RE: Transmittal of Comments – Swauk Valley Ranch Conservation Short Plat (LP-17-00007)

TO: All Staff
FROM: Justin Turnbull, County Surveyor 
DATE: November 30, 2017
SUBJECT: County Survey review of Prelim Long Plat LP-17-00007 (Swauk Valley Ranch)

RE: WDFW comments on LP-17-00007 Swauk Valley Ranch Long Plat Application

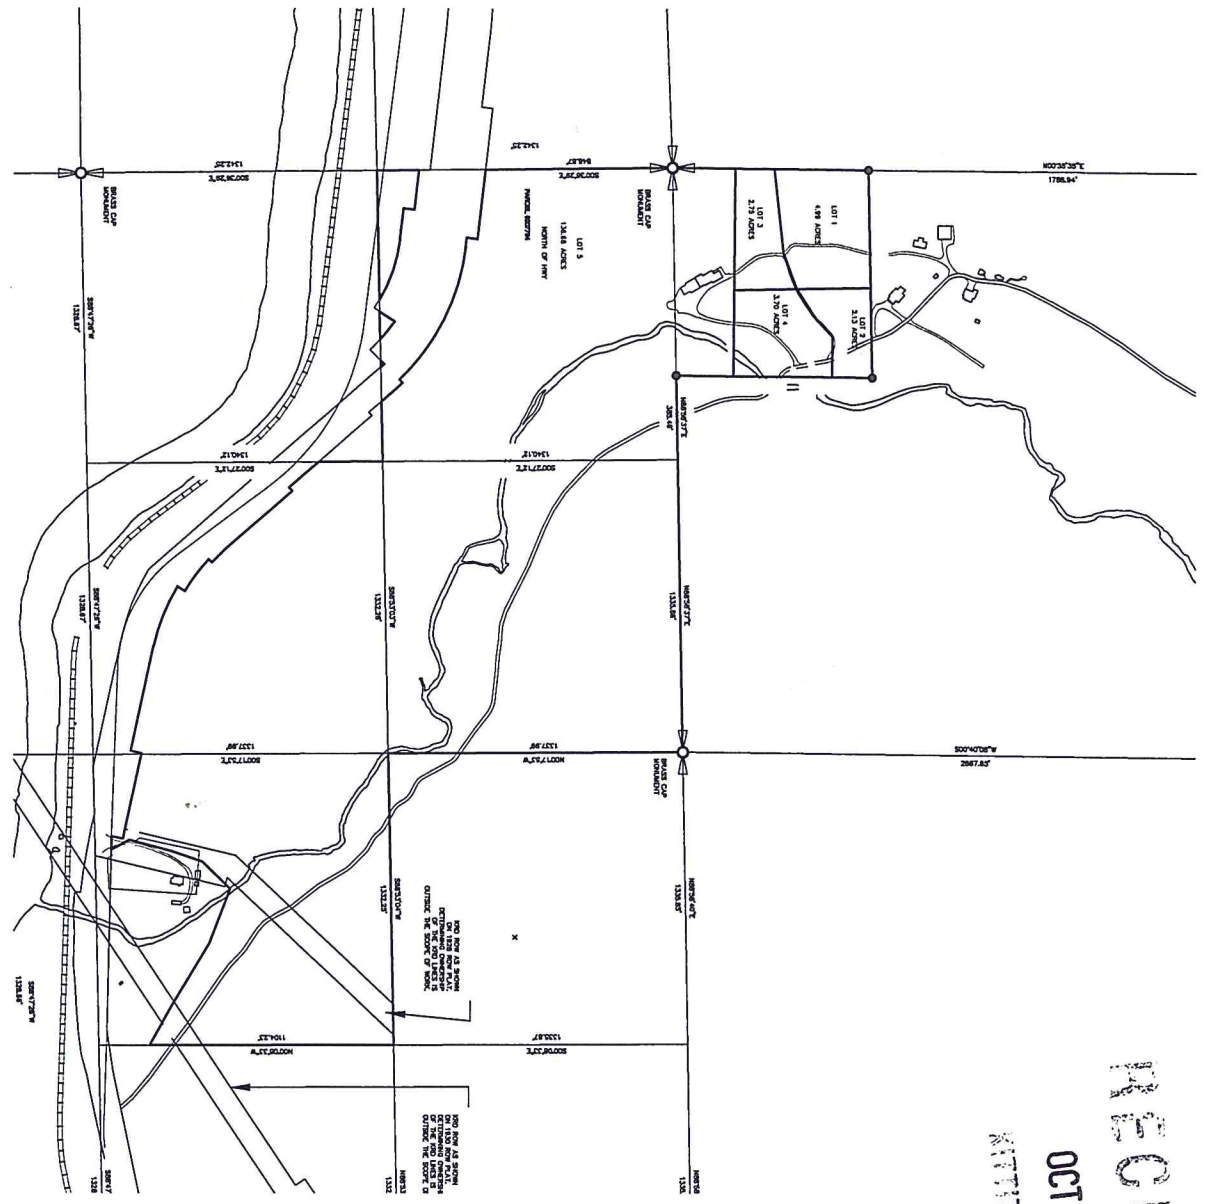
Comments Sheet 1:

10. A Vicinity Map should be shown.
11. A standard signature block will need to be shown.
12. ~~Utility providers or a statement identifying how utilities are to be addressed (water/sewer/electrical/drainage)~~ (not survey related, see note at end)
13. Set corners shown are at the wrong scale.
14. The access easement should be addressed as existing or herein dedicated. If existing, the recording number should be included, and if dedicated, the position should be mathematically retraceable.
15. The BPA access road should be identified as where it begins and the 40' Access easement ends. (or overlaps identified).
16. Adjacent survey North of parcel should be labeled (B:41, P7)

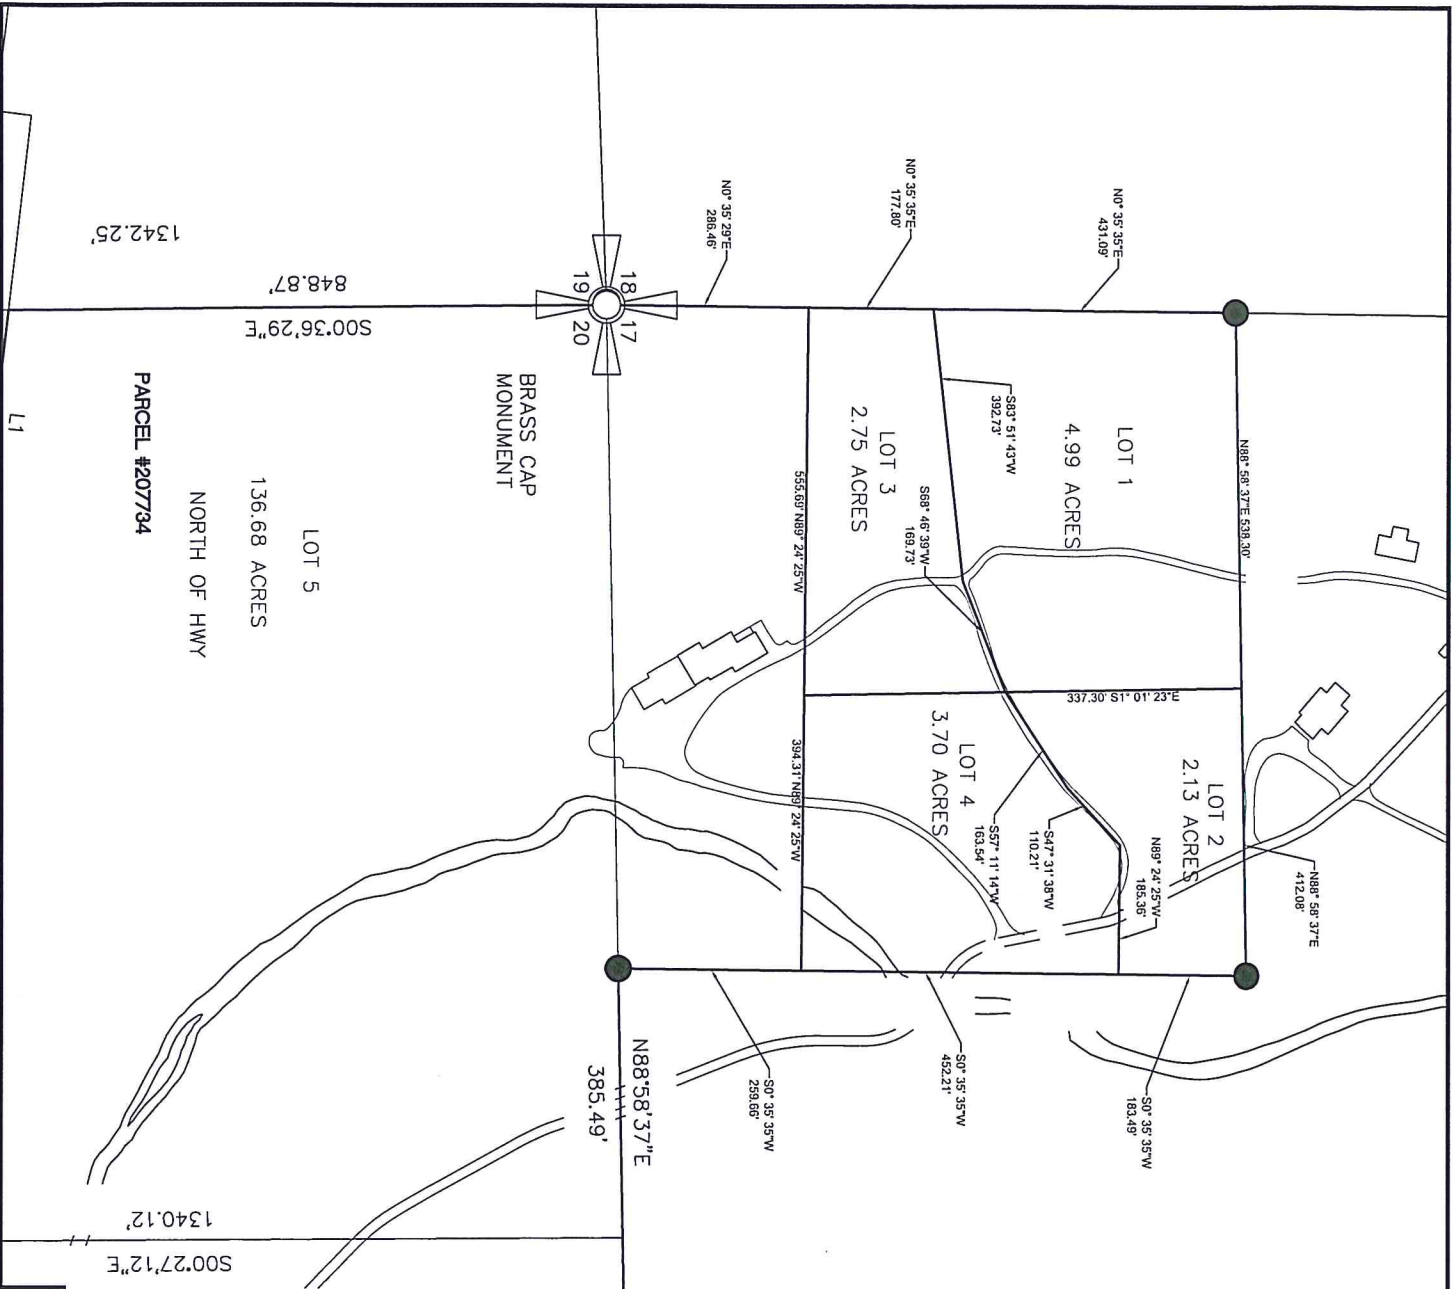
Comments Sheet 2:

17. Division lines of new lots should be staked in the field.
18. Adjacent survey North of parcel should be labeled (B:41, P7)
19. Sections identified at section symbol are misaligned.
20. The portion of the property lying south of the highway should be delineated.
21. The distance from existing building corners to existing and proposed lot lines should be shown.
